**Consultation Response from KC,
Highways Development Management**

2024/92107 The Piggery, Burnt Platts Lane, Slaithwaite, Huddersfield, HD7 5UZ

Erection of extension and alterations to existing stable block to form one dwelling with access and associated works

Date Responded: 03/12/2024.

Drawing Title\_  
AS PROPOSED\_ SITE + LOCATION PLAN

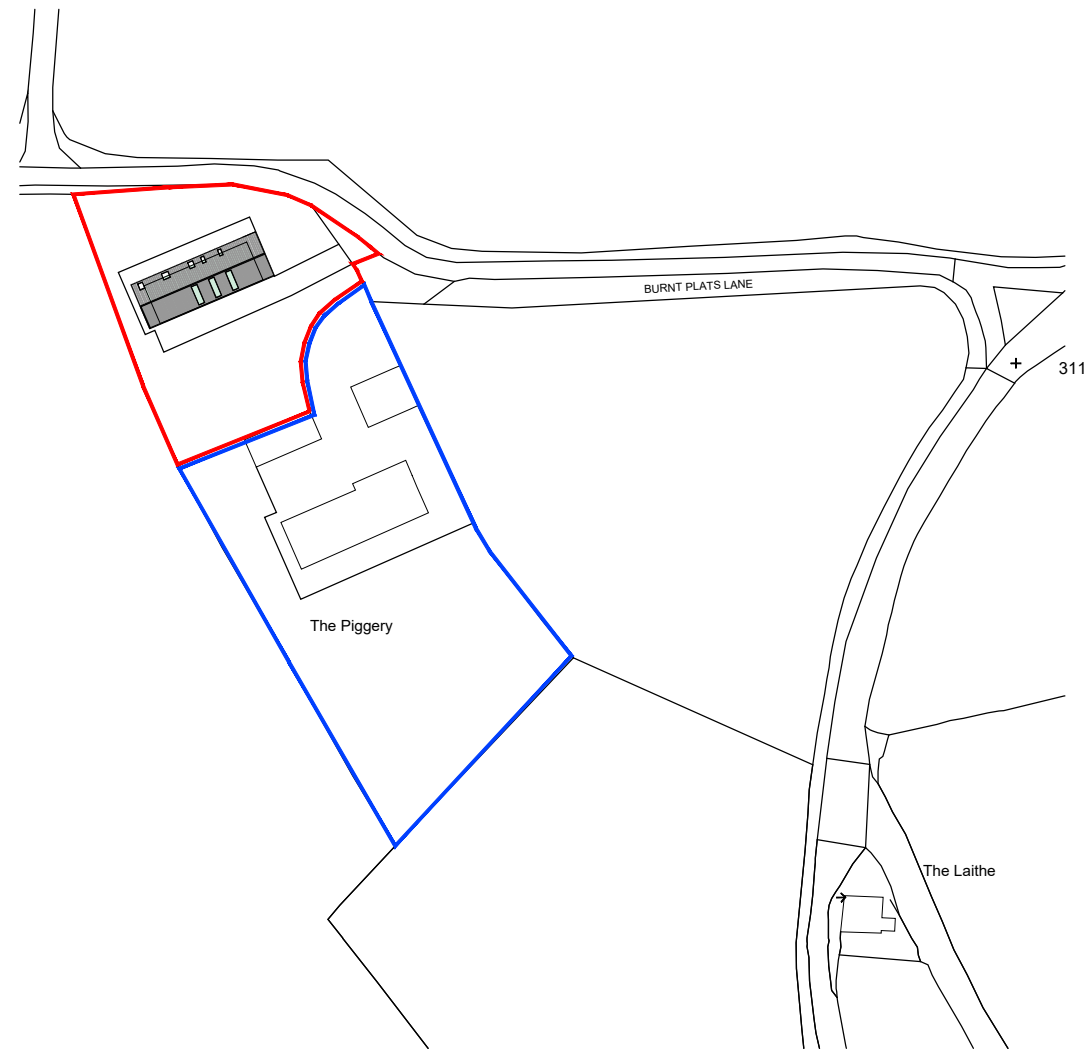
Vehicle access to the site from Burnt Platts Lane will remain as existing and is unaffected by the proposals.

The proposals are not expected to intensify the use of this access.

Four car parking spaces are proposed which is acceptable.

The approved vehicle parking areas will need to be surfaced and drained in accordance with the Communities and Local Government; and Environment Agencies 'Guidance on the permeable surfacing of front gardens (parking areas)' published 13th May 2009 (ISBN 9781409804864) as amended or superseded.
